Please ask for: Nicola Moore
Email: nicola.moore@arun.gov.uk
Telephone: Ext 37944
Our Ref: AW/325/20/CLP
Your Ref:
Date: 16th November 2020

Lawful Development Certificate for a Proposed Use or Development

Development: Lawful development for a proposed conservatory on side of existing dwelling, and remove existing wall and replace with new fence.
Location: 22 Regis Avenue Aldwick PO21 4HQ

22, Regis Avenue, Aldwick, West Sussex, PO21 4HQ

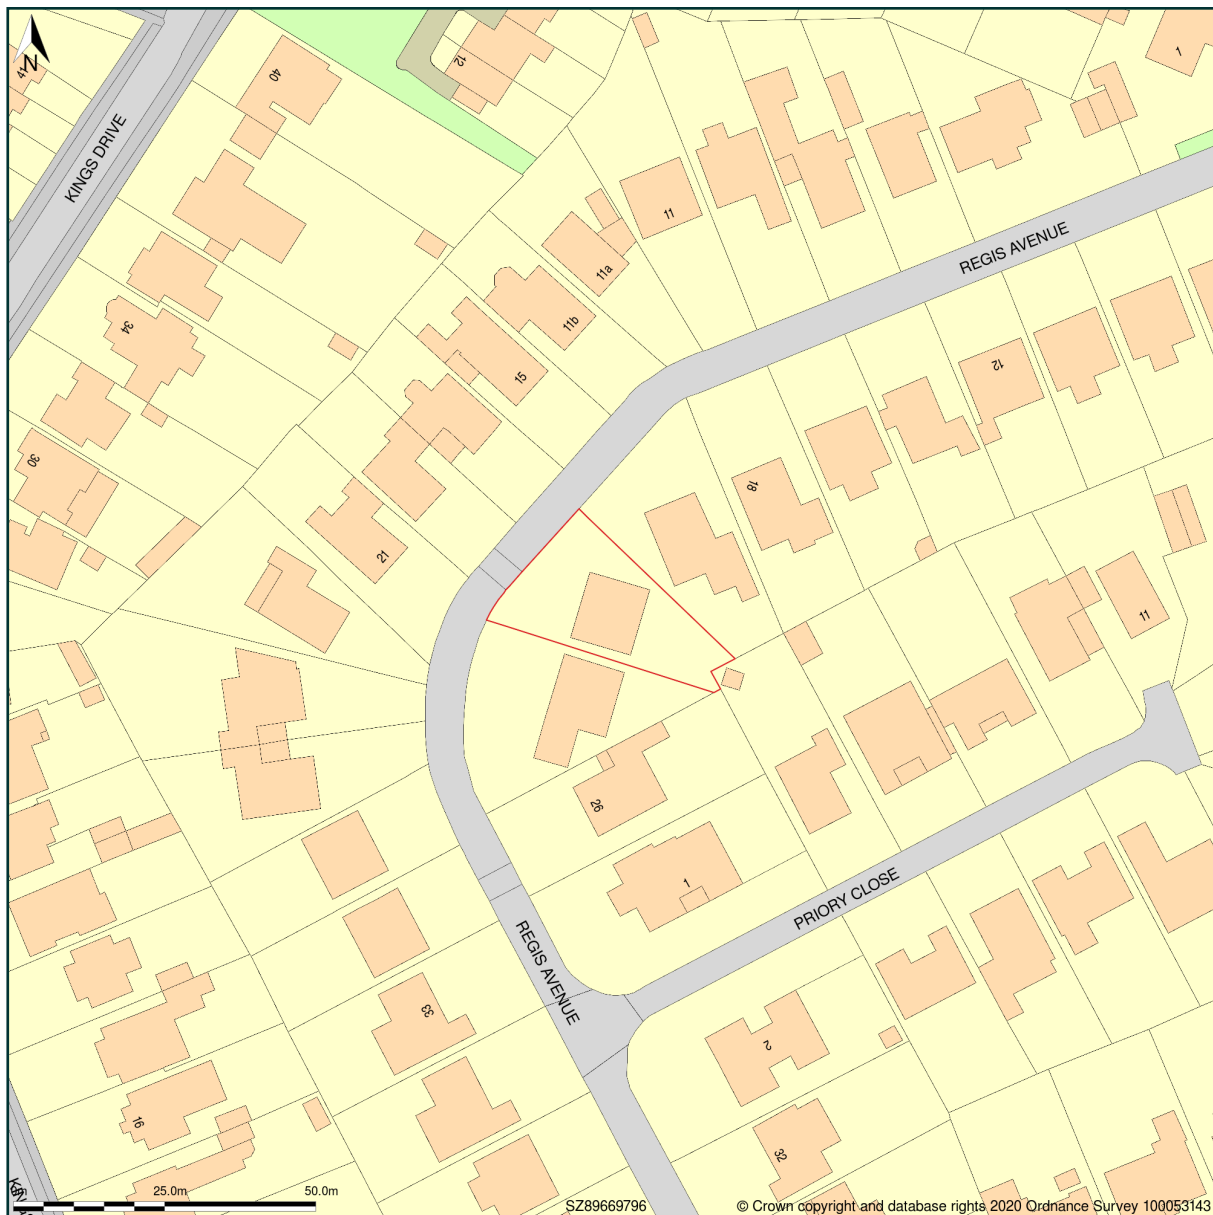
Block Plan

Please amend the Block plan to show the proposed development in relation to the existing dwelling (this can be hatched or highlighted) and include dimensions to boundaries.

Proposed Elevations

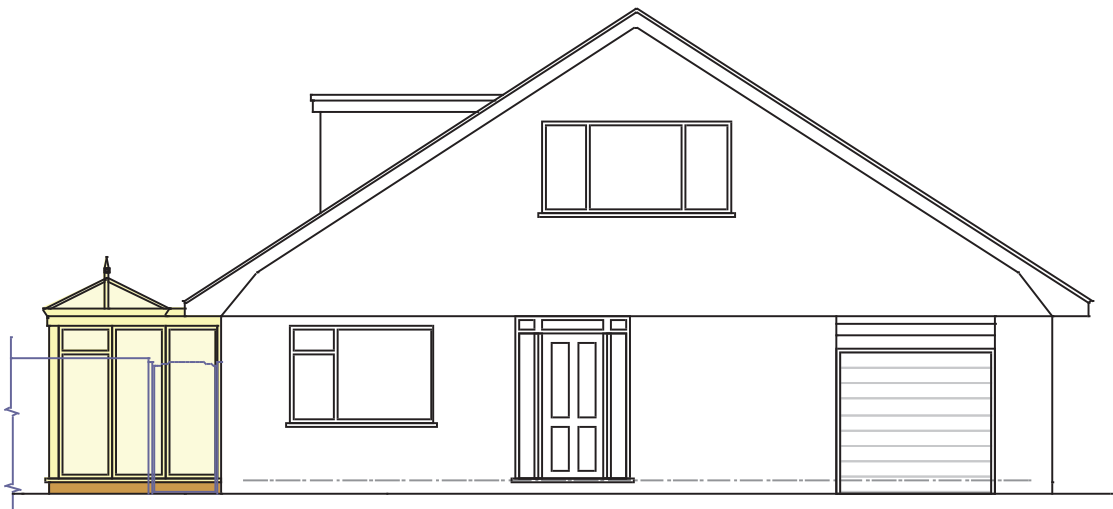
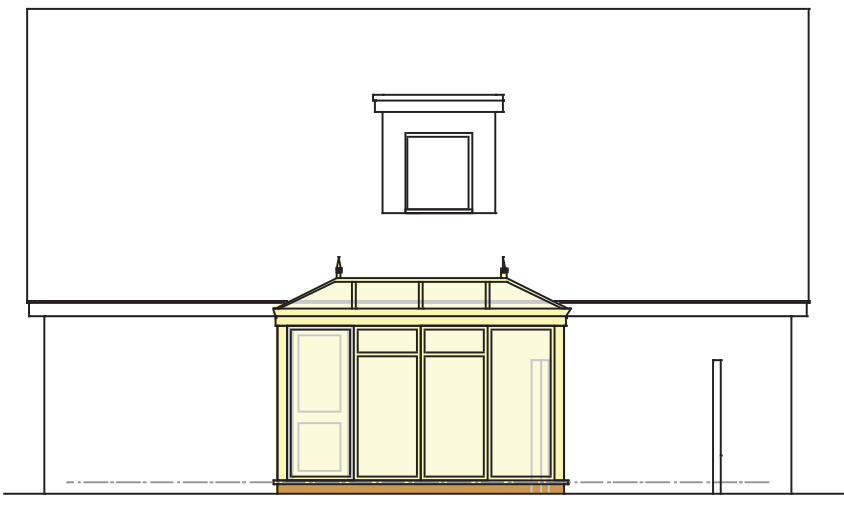
Elevations

Please submit 1 electronic or 3 paper copies of clearly labelled existing and proposed elevations at a scale of 1:50 or 1:100. Further details can be found in the Validation Requirements List.

Proposed Ground Floor

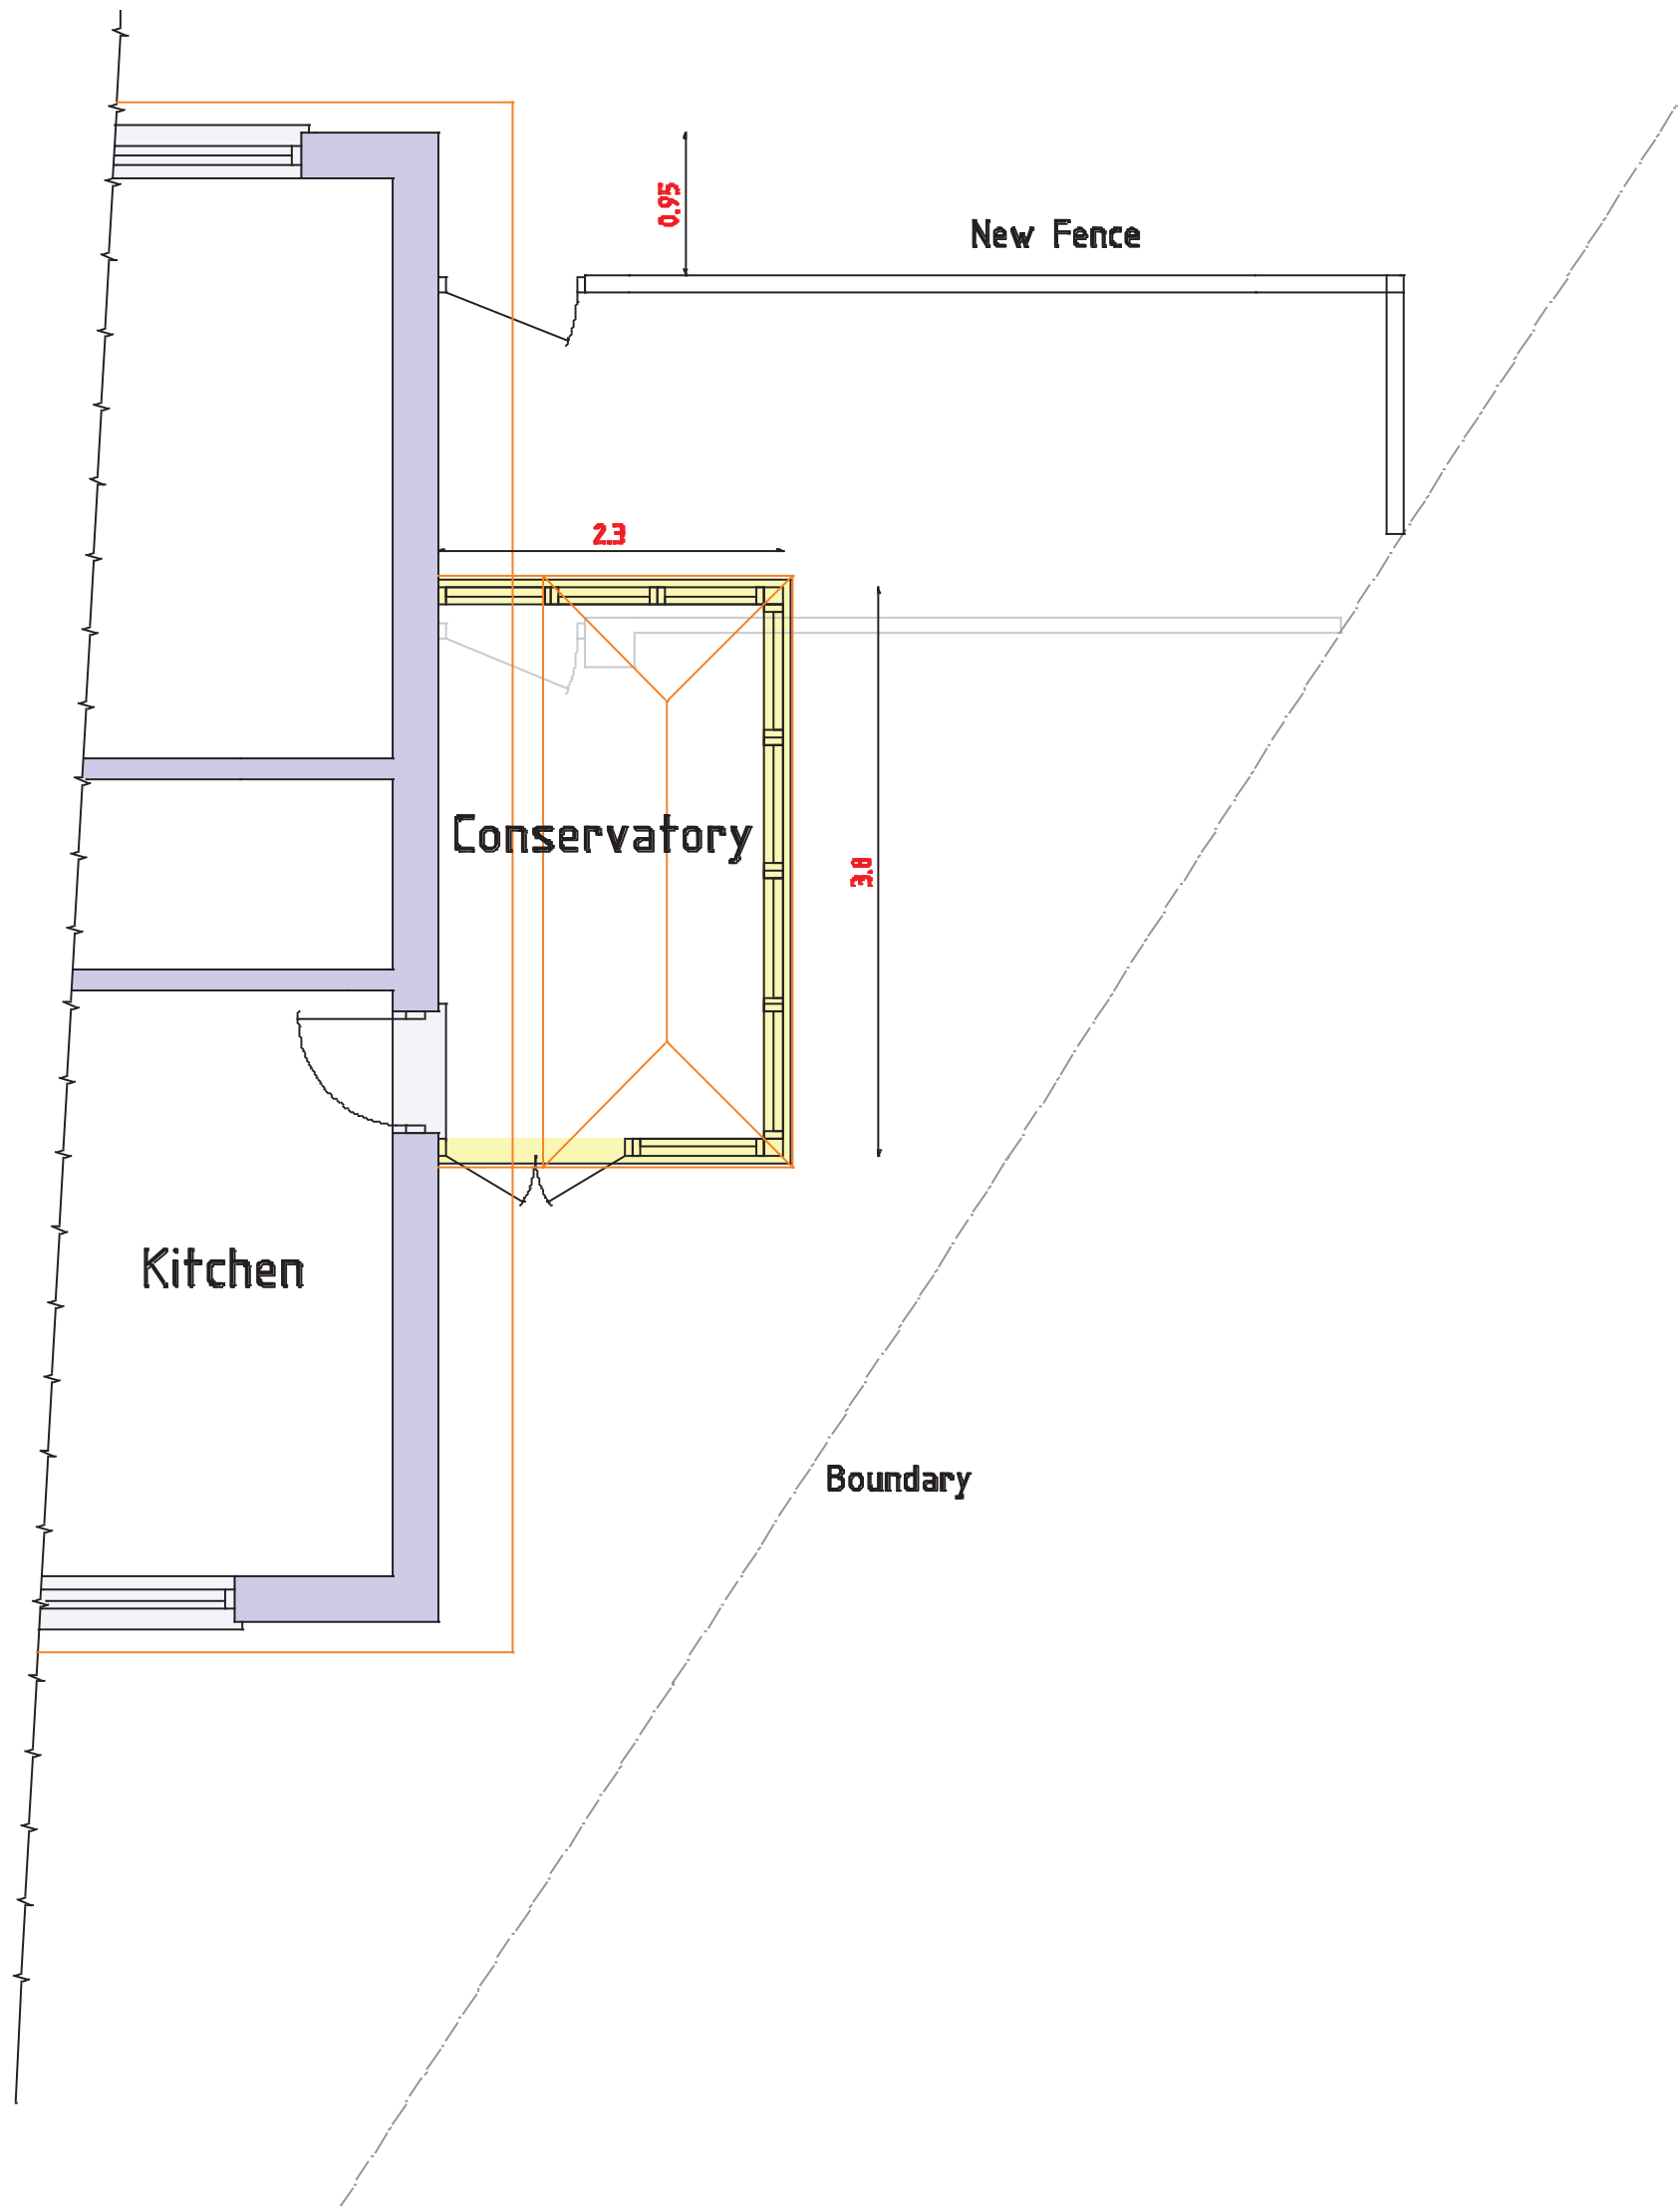
Floor Plans

Please submit 1 electronic or 3 paper copies of clearly labelled existing and proposed floor plans at a scale of 1:50 or 1:100. Further details can be found in the Validation Requirements List.
